Rezoning Transportation Analysis
Petition Number: Insert Zoning Petition #2021-036
General Location Identifier: Tax ID 06306125

Revision Log:	Date	Description
	04-29-21	First Review (EL)

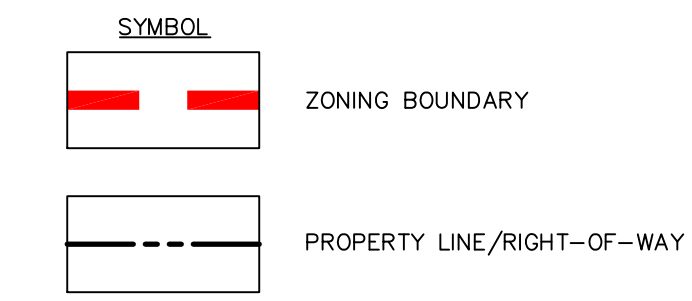
1. **Curbline:** The proposed zoning district has a setback measured from back of the existing or proposed future curbline.
 - a. **South Hoskins Road:** The future location of curb and gutter is 27.5-feet from road centerline. While the existing curb and gutter may remain in place, show the future curbline location for reference.

- b. **Gossett Avenue:** The future location of curb and gutter is in its existing location.

Label and dimension the curb and gutter from the centerline for each road on the site plan.

3. Revise the site plan and conditional note(s) to commit to construct an 8-foot planting strip and 6-foot sidewalk on South Hoskins Road, labeled and dimensioned from the road centerline and future curb line location, in support of the Charlotte WALKS Council-adopted policy. Replace the existing accessible ramp at the intersection with two standard CLDSM PROWAG directional ramps.

4. Site plan and conditional note(s) revisions are needed to dedicate and dimension 43.5-feet of right-of-way from the South Hoskins Road centerline, to accommodate the future cross section that accommodates a buffered bike lane facility per the Charlotte BIKES Council-adopted policy.
5. Site plan and conditional note(s) revisions are needed to correct the driveway call-out below.

6. A site plan note(s) specifying dedication and fee simple conveyance of all rights-of-way to the City before the site's first building certificate of occupancy is issued is needed. CDOT requests rights-of-way set at 2' behind back of sidewalk where feasible.
7. A site plan note specifying that all transportation improvements will be approved and constructed before the site's first building certificate of occupancy is issued is needed. The petitioner may phase transportation improvements if said improvements and phasing are explicitly described in site plan notes.
